Stage 1 Road Safety Audit Response
Roslyn Avenue, Netherton, Huddersfield
Harron Homes

Job No.	EE100025		
Project	Roslyn Avenue, Netherton, Huddersfield		
Location	Roslyn Avenue, Netherton, Huddersfield		
Title	Stage 1 Road Safety Audit Response		
Document Ref	RSA	Issue/Status	Detailed Design
Date	12 th March 2026		
Prepared by	Steven Griffiths	Signature (for file)	
Checked by	Steven Griffiths	Signature (for file)	
Authorised by	Steven Griffiths	Signature (for file)

Stage 1 Road Safety Audit

P6	Pedestrian crossing adjacent Plot 67 added.	SG	12.03.26
P5	Road names added.	SG	06.02.26
P4	Site layout plan updated.	SG	27.01.26
P3	Site layout plan updated.	SG	21.10.25
P2	Site layout plan updated.	SG	06.10.25
P1	First Issue	SG	30.09.25
rev	description	drawn	date
Preliminary

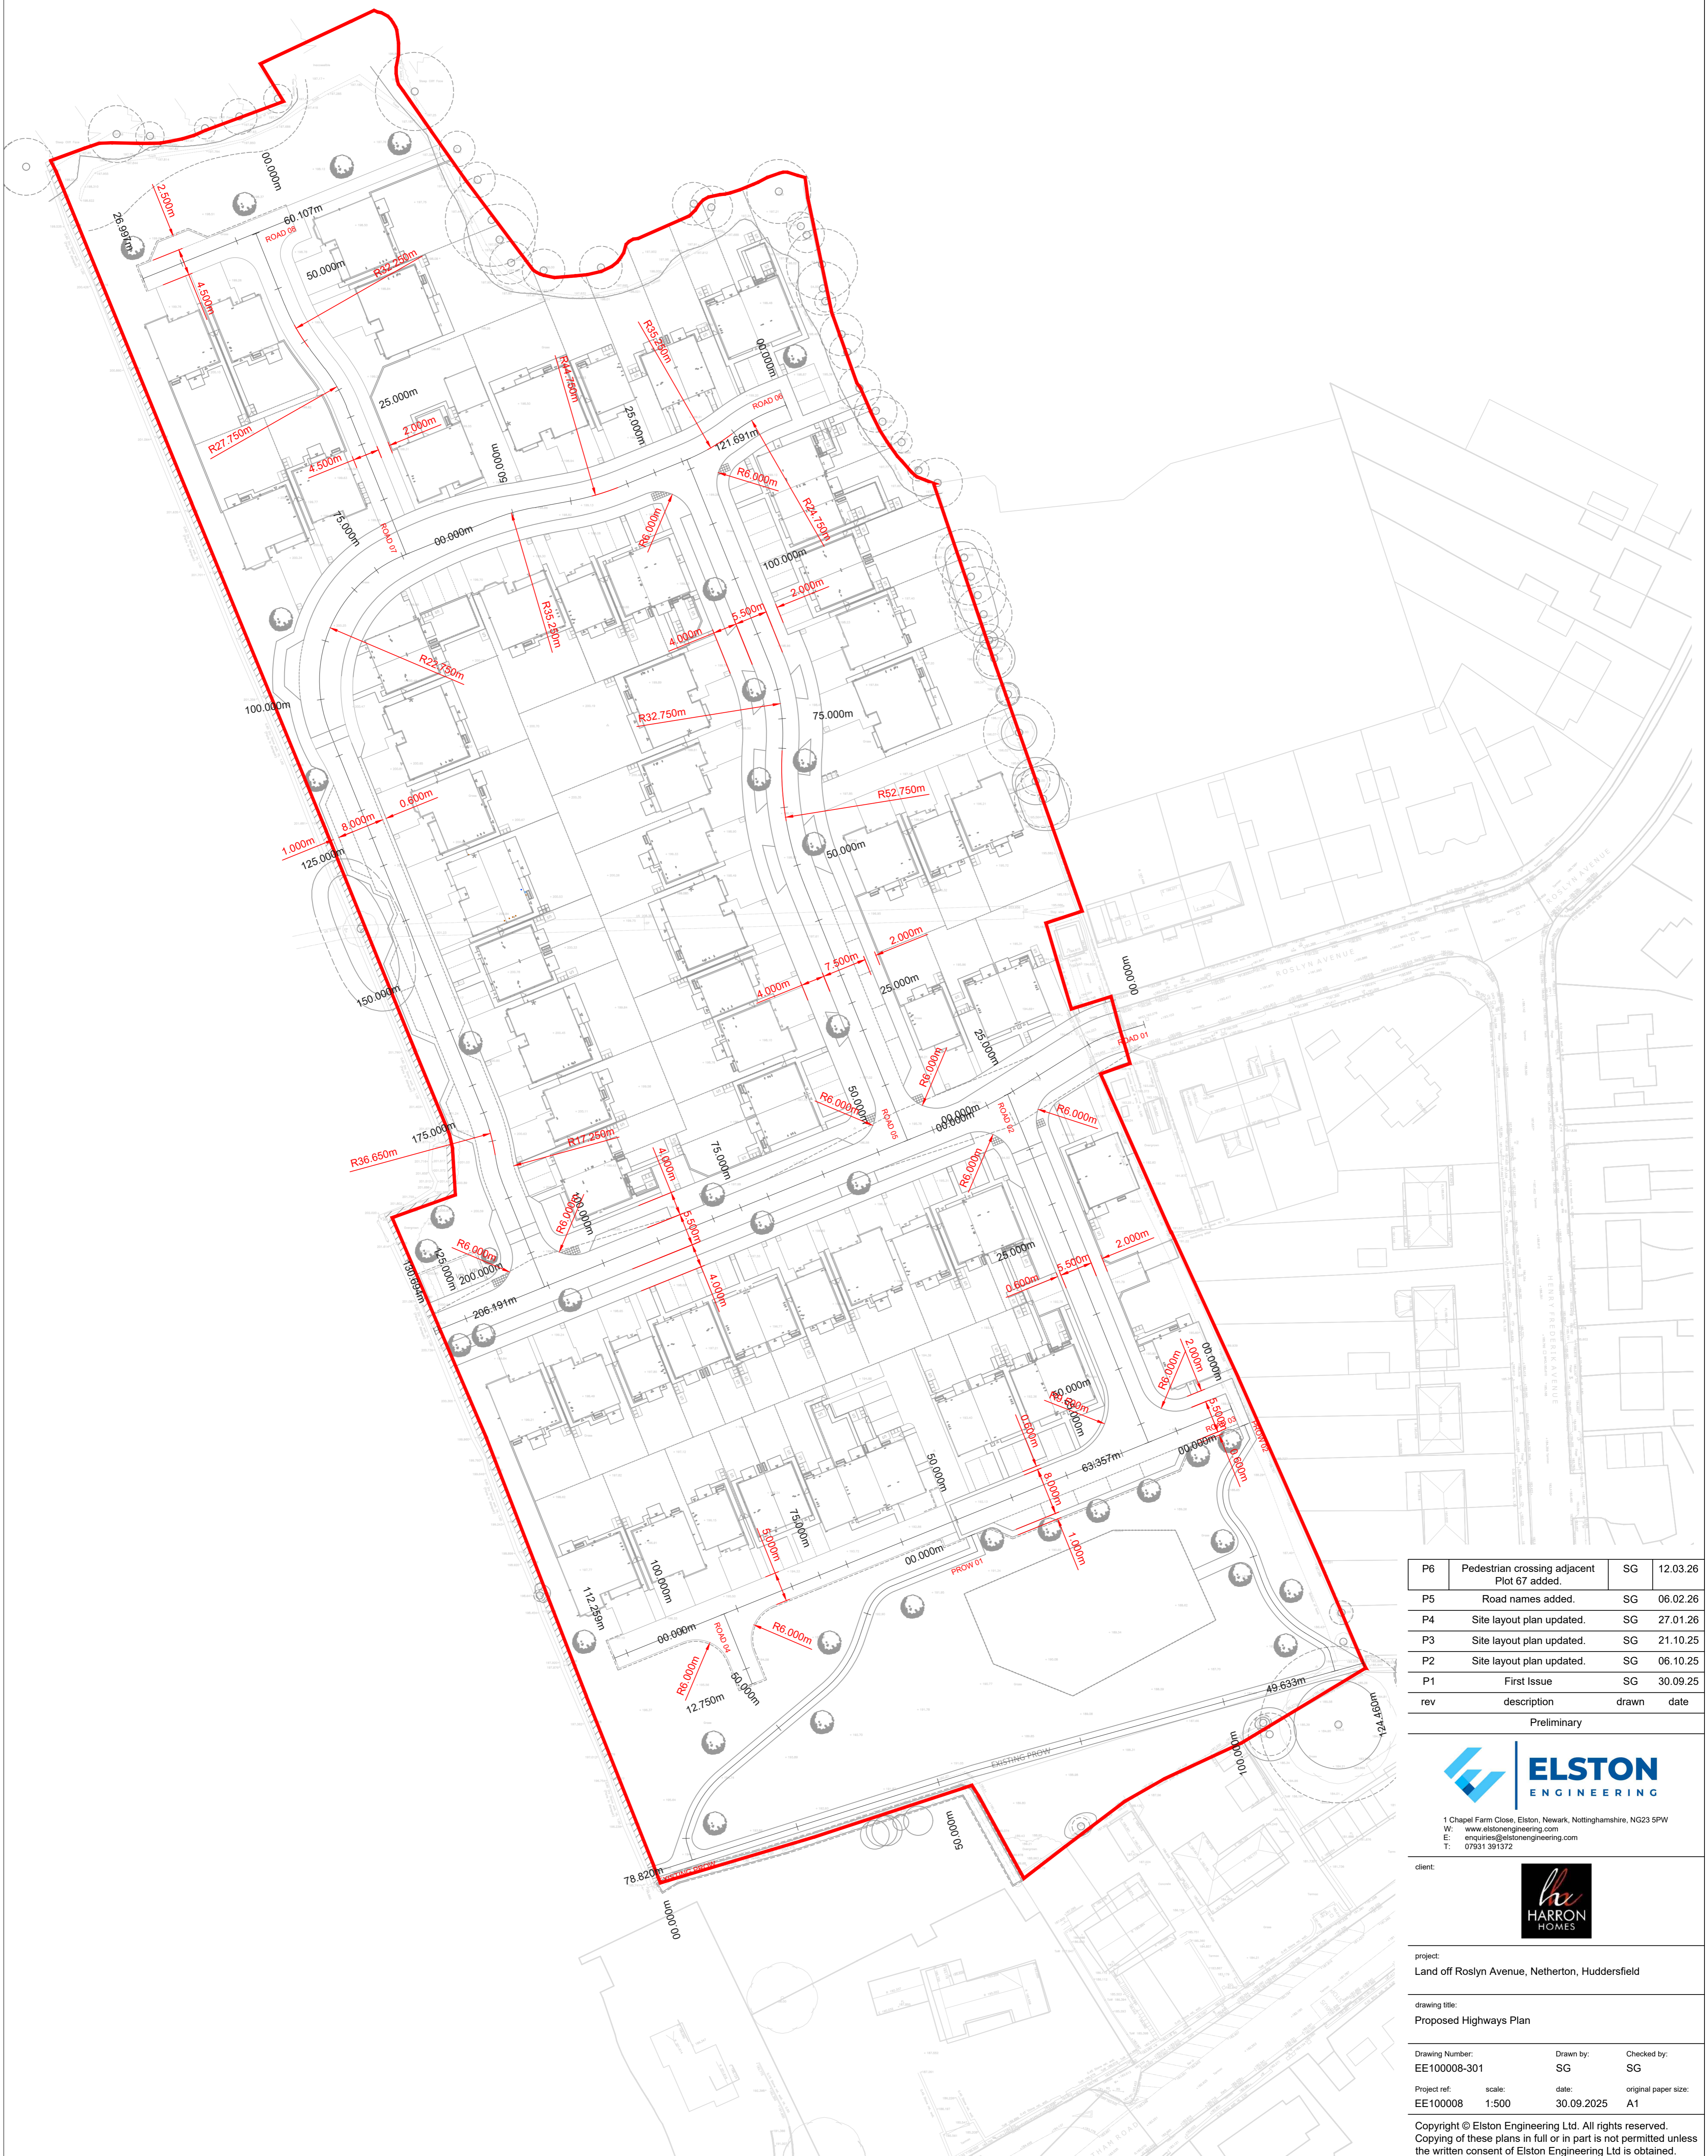
Proposed dropped kerb pedestrian crossing facilities are indicated on the Section 38 Layout Plan at the majority of significant junctions within the development. However, no dropped crossing provision is shown at the junction located at the north-east end of the loop road. There is a footpath link to and from the development adjacent to Plot 67 that connects to this junction, which is likely to generate pedestrian movements across the carriageway at this location. The absence of a dropped crossing may therefore result in an inconsistent level of pedestrian provision and may create difficulties for mobility-impaired users, wheelchair users, and those with pushchairs attempting to cross the carriageway. This may discourage pedestrians from using the footway network as intended or lead to informal crossing at locations without appropriate tactile paving or level access.

It is recommended that a dropped kerb pedestrian crossing point be included in the design at this junction including appropriate tactile paving.

Tactile paved pedestrian crossing included at the junction adjacent Plot 67 to aid pedestrian movements.
